Ribble Valley Borough Council
Housing & Development Control

Application no: **3/2020/0675**

Address: **Ribble Valley Care Home Sawley Old Brow Sawley BB7 4LF**

Proposal: **Part demolition of bedrooms to rear of building and full demolition of existing conservatory to the main entrance area. Construction of walls under existing canopy at entrance door, erection of new sun room in place of demolished conservatory and construction of new single storey extension to rear of property replacing partly demolished structures and associated parking**

**Proposed Site Plan**  
Scale 1:500

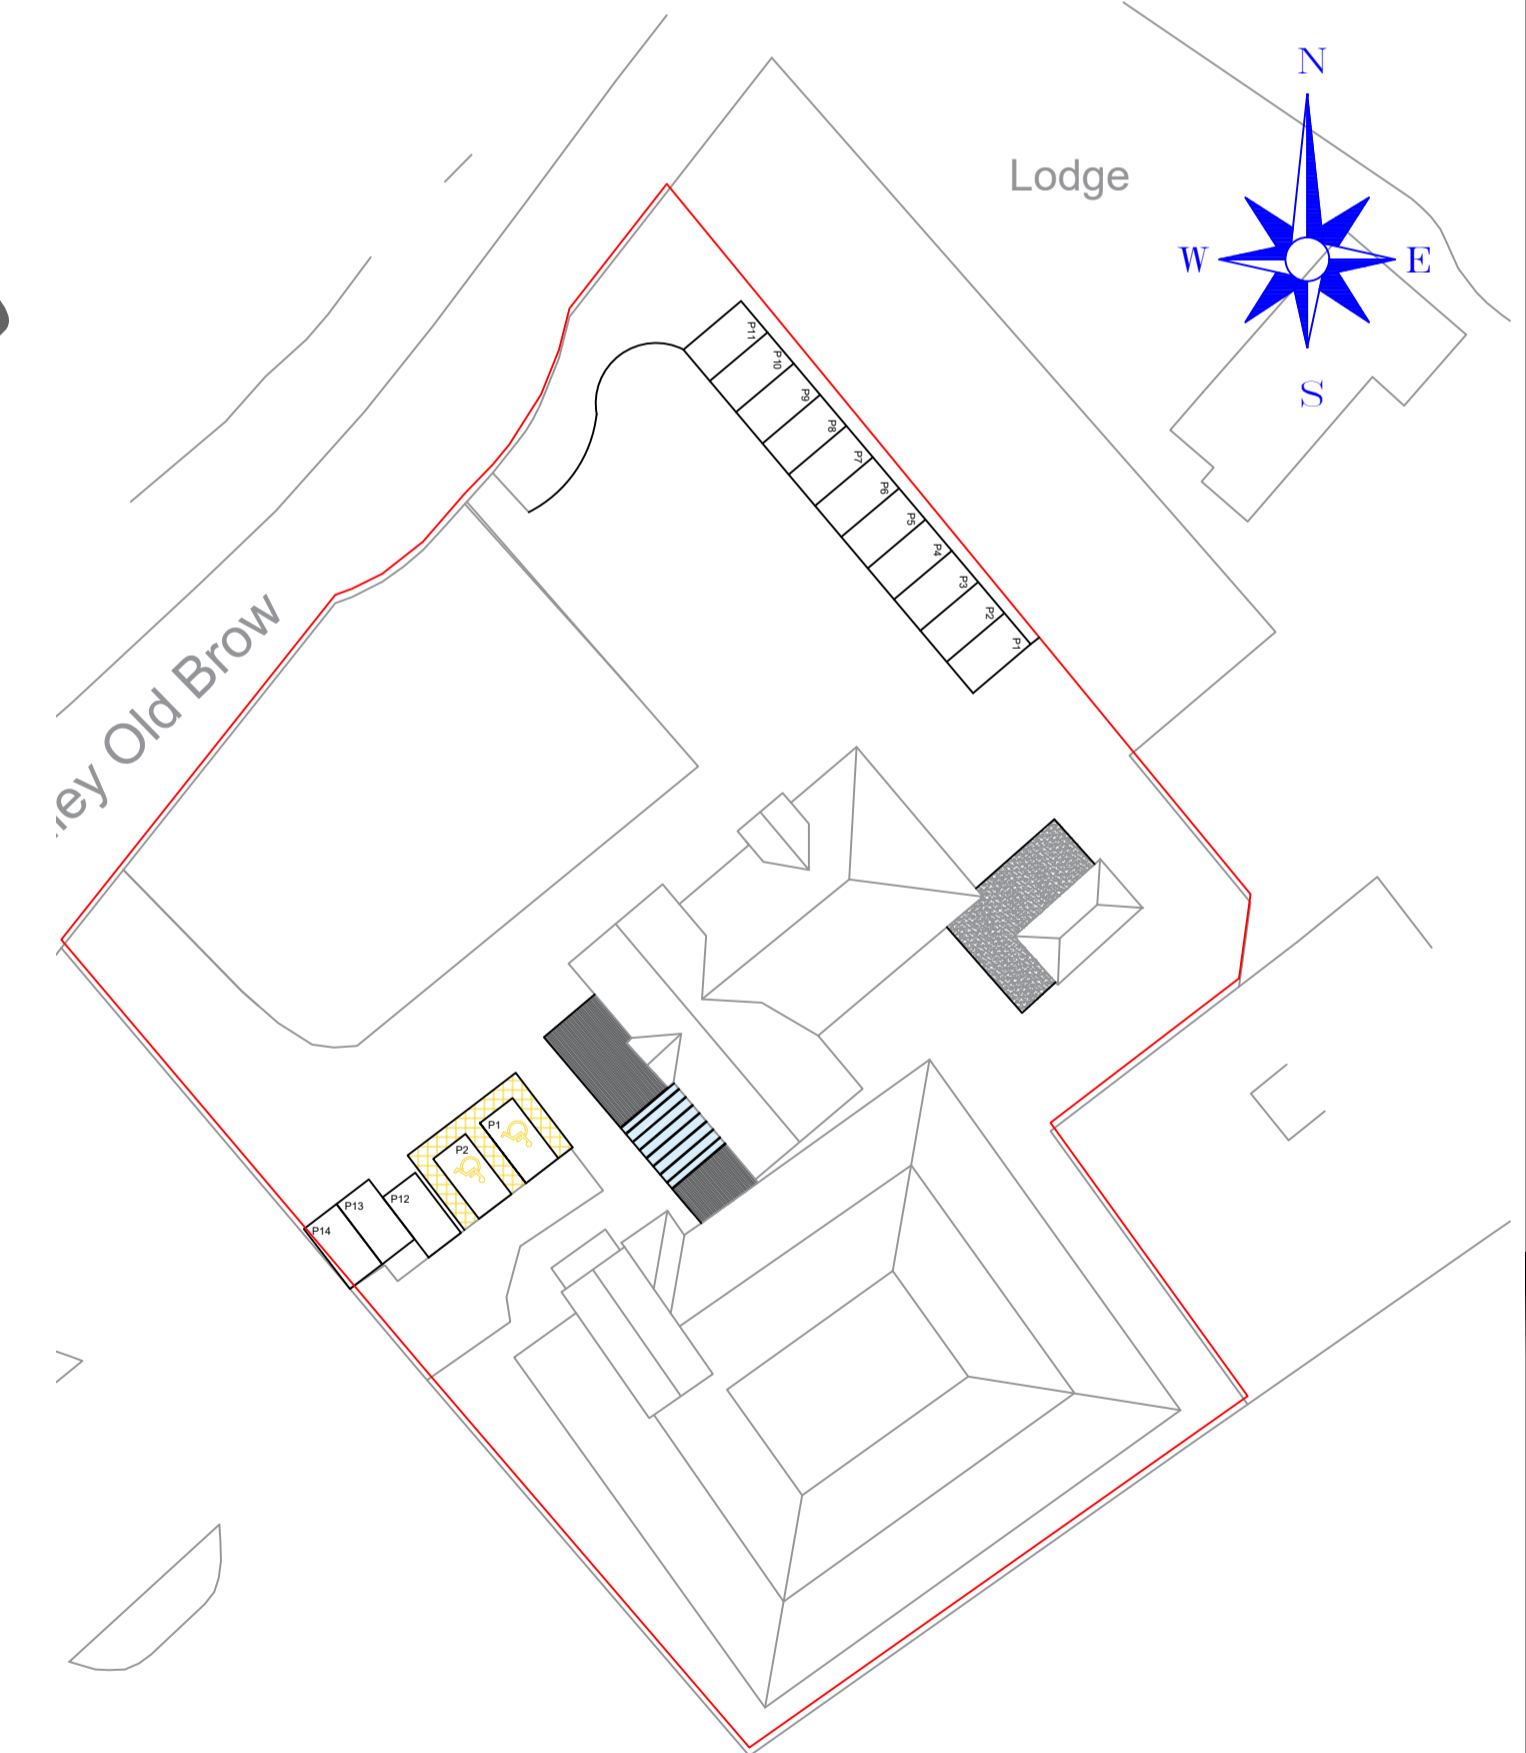
The submitted application form refers to a proposed total of 18 parking spaces while the proposed layout illustrates only 16 parking spaces. There is a large grassed area to be removed and replaced with a large parking area, the existing and proposed ground levels towards the boundary wall along Sawley Old Brow appear to be undergoing some level of change in order to accommodate the proposed parking spaces near to the boundary wall and the gradient from the current grassed area down

to the boundary wall is likely to increase due to this. I ask that a design and access statement is provided to justify the increased parking provision and also a more detailed parking layout is provided including any level differences to the front of the parking area adjacent to the boundary wall running along Sawley Old Brow.
